# REUNION HOMES INC.

## Notice to Adjacent Property Owners

Lots 110 and 111 in The Vistas Filing No. 1 at Meridian Ranch

REPLAT/LOT LINE ADJUSTMENT LOTS 110 AND 111 IN THE VISTAS FILING NO. 1 AT  
MERIDIAN RANCH

THE VISTAS FILING No. 1A

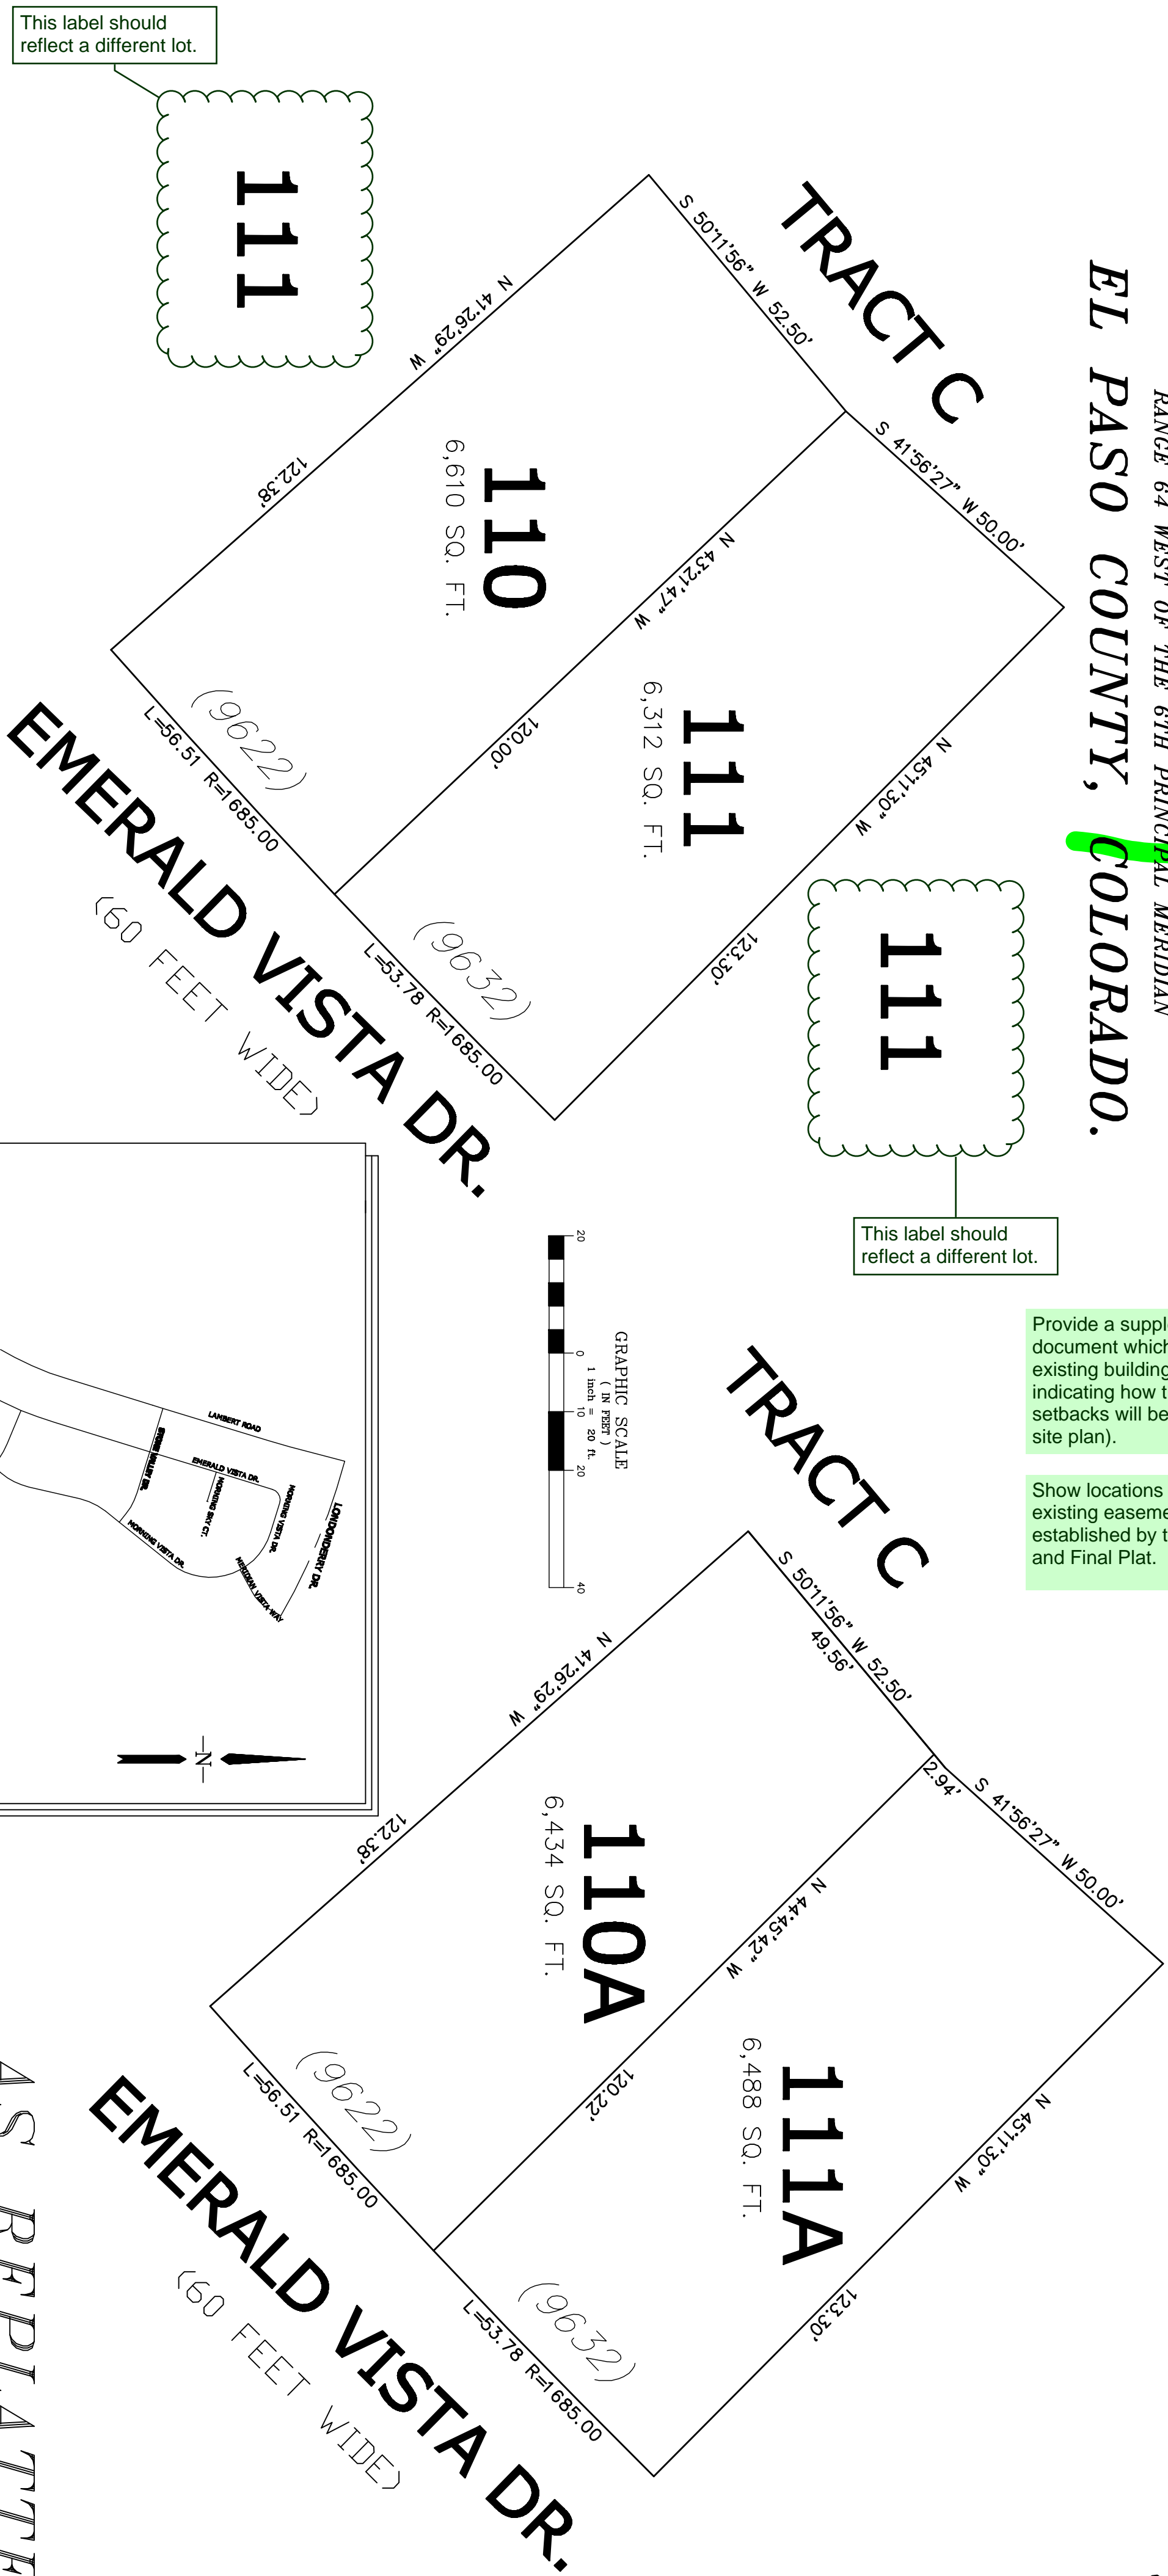
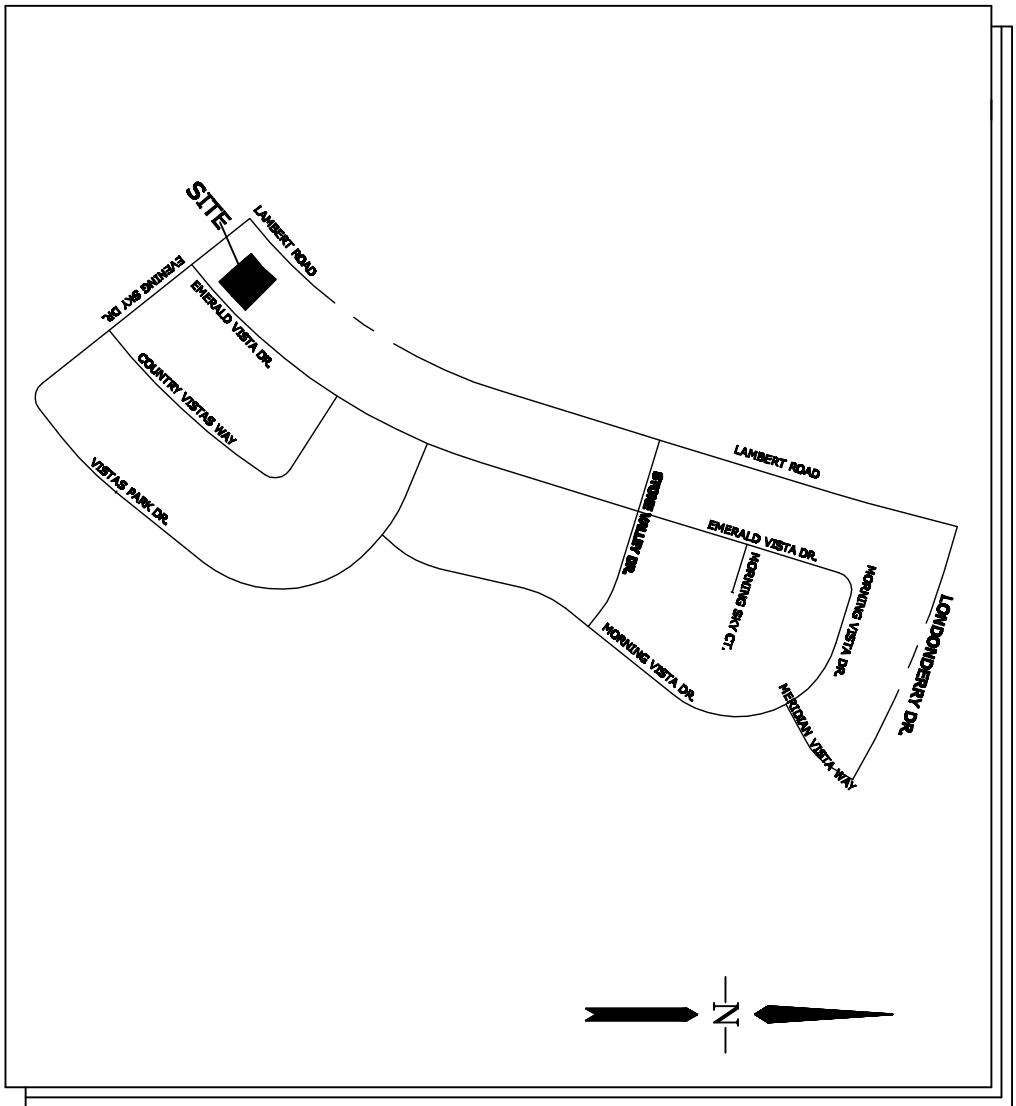
Incorrect lots listed.

Provide certified mail receipts for all neighbors who were notified.
